**Consultation Response from KC,
Lead Local Flood Authority**

2026/90211 West House, Oxford Road, Gomersal, Cleckheaton, BD19 4AU

Erection of residential development for 9 dwellings with associated works

Date Responded: 18/03/2026.

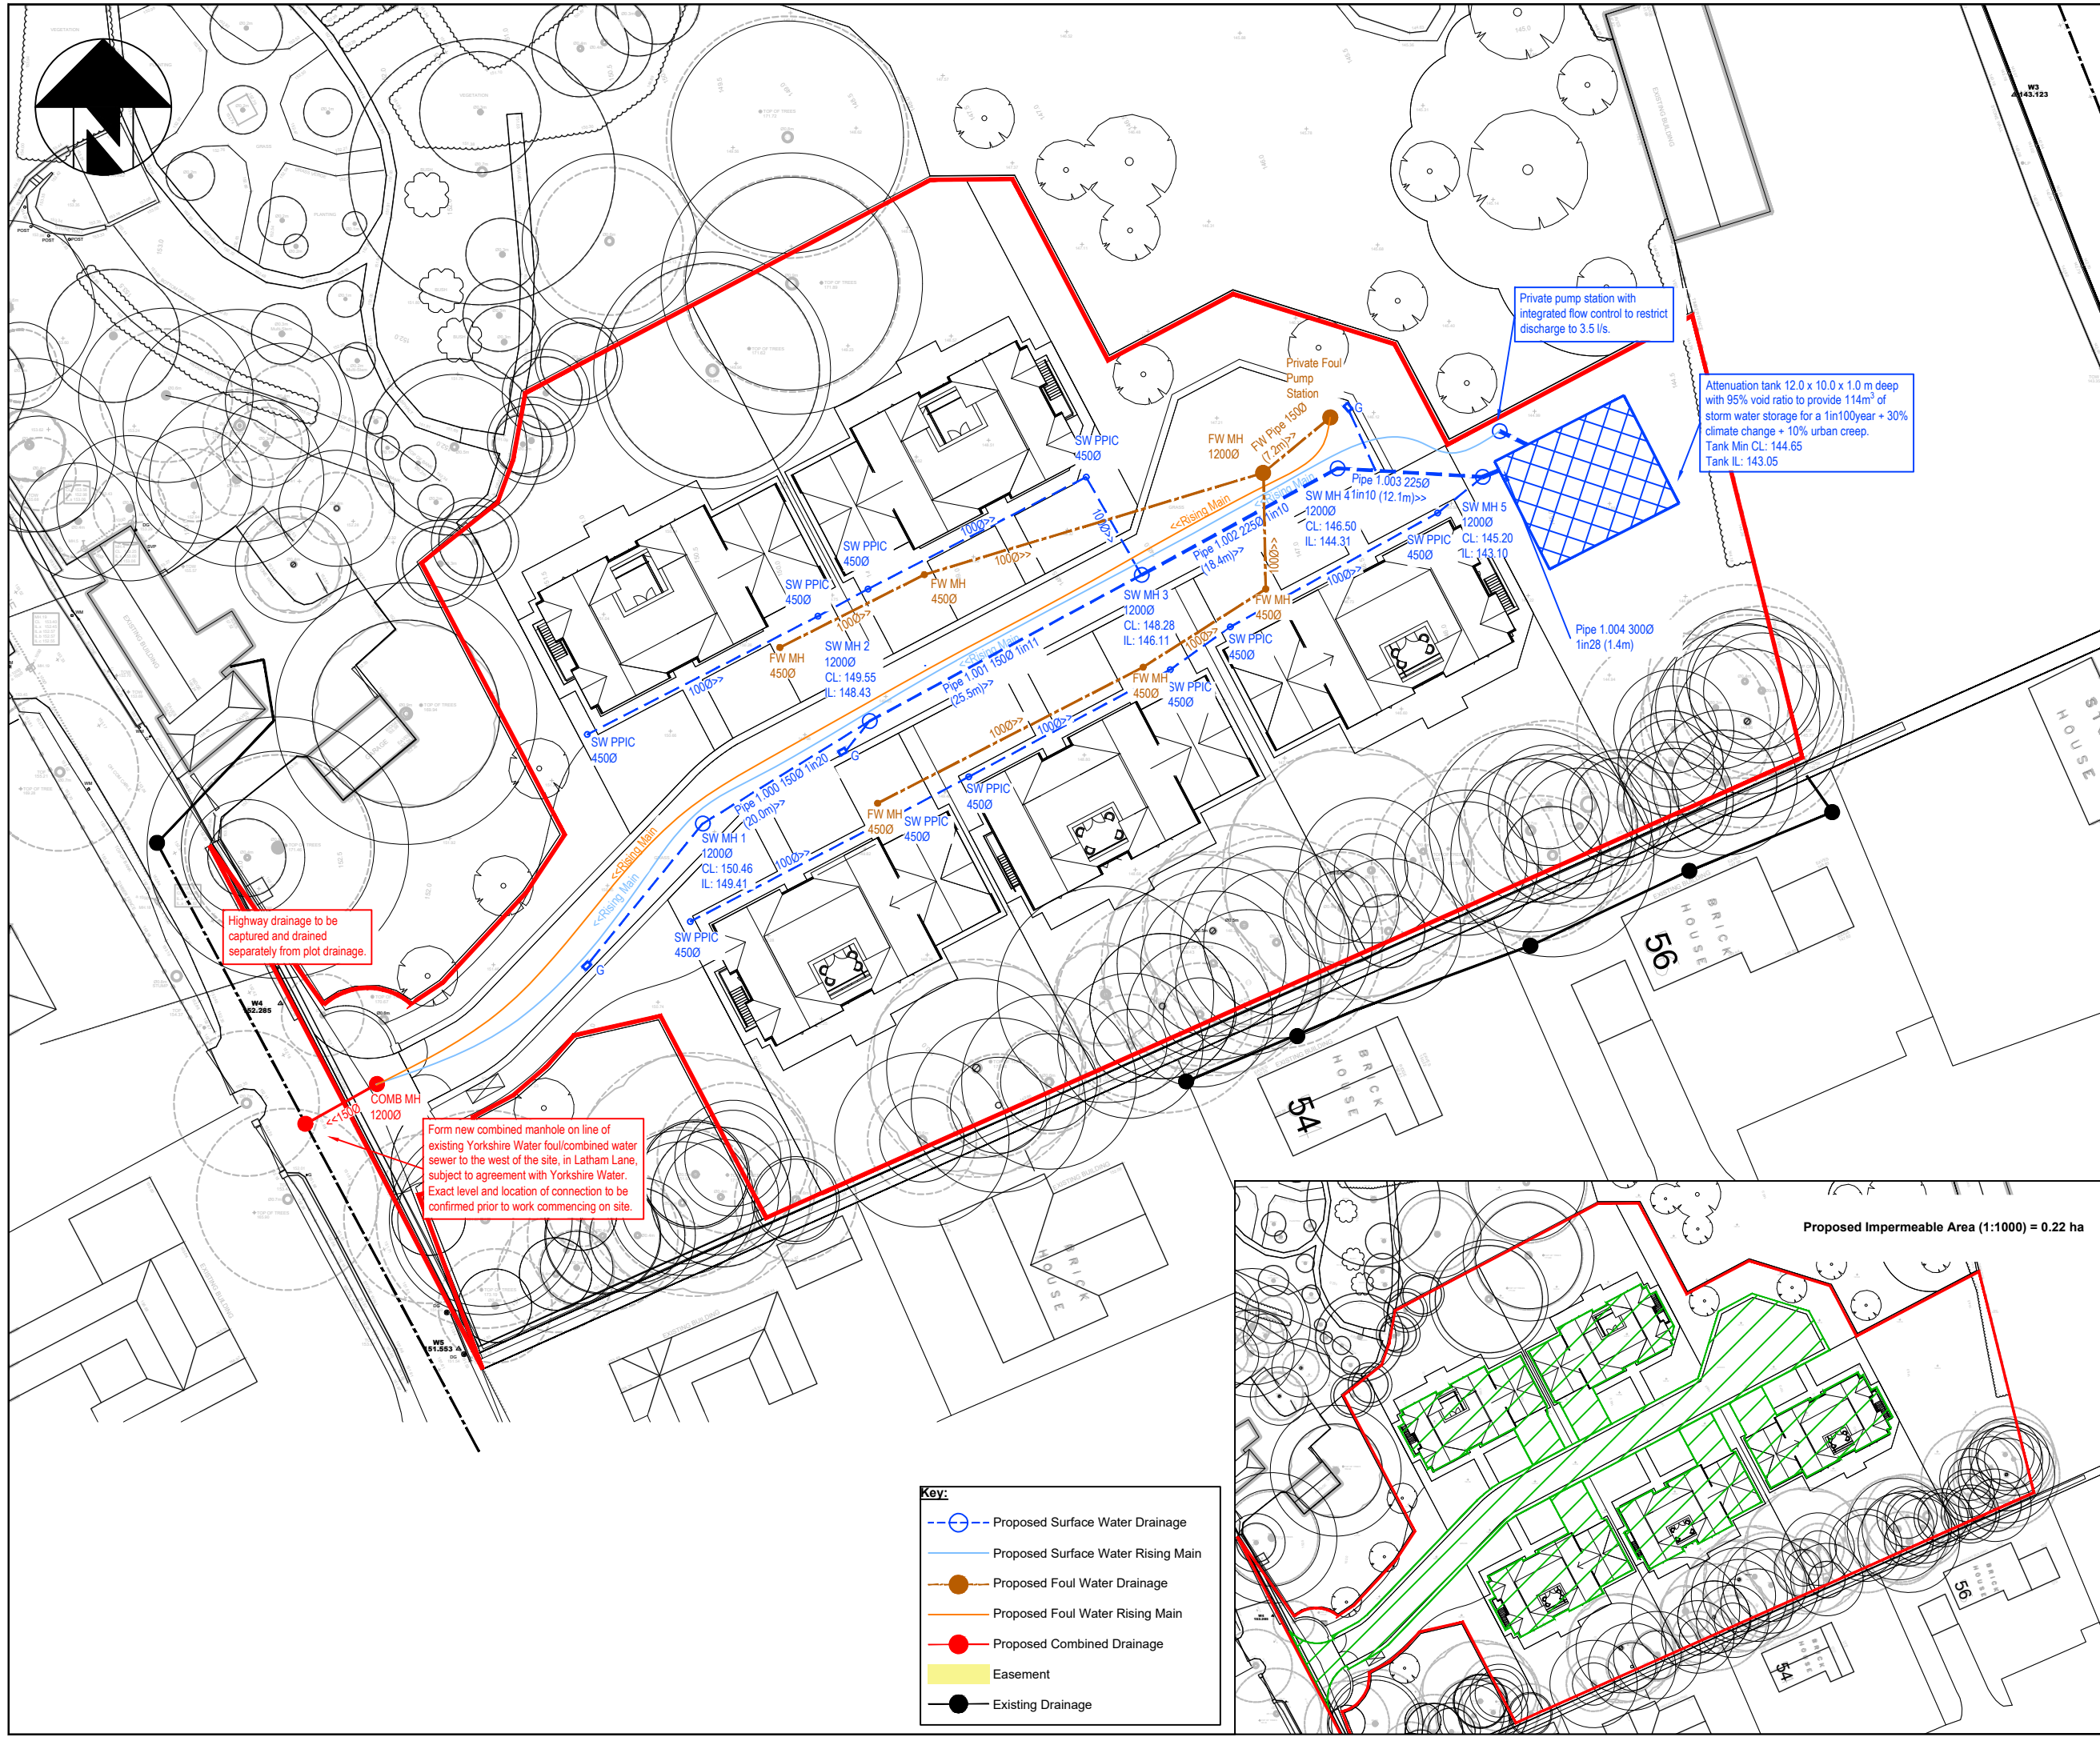
The LLFA notes that the development is split into two separate areas with the northern area discharging attenuated surface water at 3.5l/s into the YW 225mm dia Combined sewer is Oxford Road. However, it is further noted that for the southern area, it is proposed to pump surface water at 3.5l/s to the YW 100mm dia sewer in Latham Lane (note that this may exceed the available capacity of this sewer). The LLFA generally will not accept pumping as an option for surface water disposal due to the risk of flooding in the event of a power or mechanical failure of the pump/s unless the pumping station is built to adoptable standards and adopted by Yorkshire Water.

The 3.5l/s allowable discharge rate should apply to the whole of the development and cannot be applied separately to each of the northern and southern areas. This restriction is also reflected in the YW response contained in Appendix H of the FRA.

It is noted that ground levels in the southern area are some 2.4m higher than those in the northern area – therefore it should be feasible to drain surface water to the northern outfall and provide a suitably sized attenuation tank at that location based on a single 3.5l/s allowable discharge rate into the Oxford Road sewer. Alternatively, additional infiltration testing at a greater depth could be carried out in the southern area and an appropriately sized soakaway tank provided.

Kirklees Flood Management and Drainage as Lead Local Flood Authority OBJECTS to this application on the grounds that an acceptable drainage strategy has not been provided (based on a single 3.5l/s allowable surface water discharge rate to the YW sewer network)
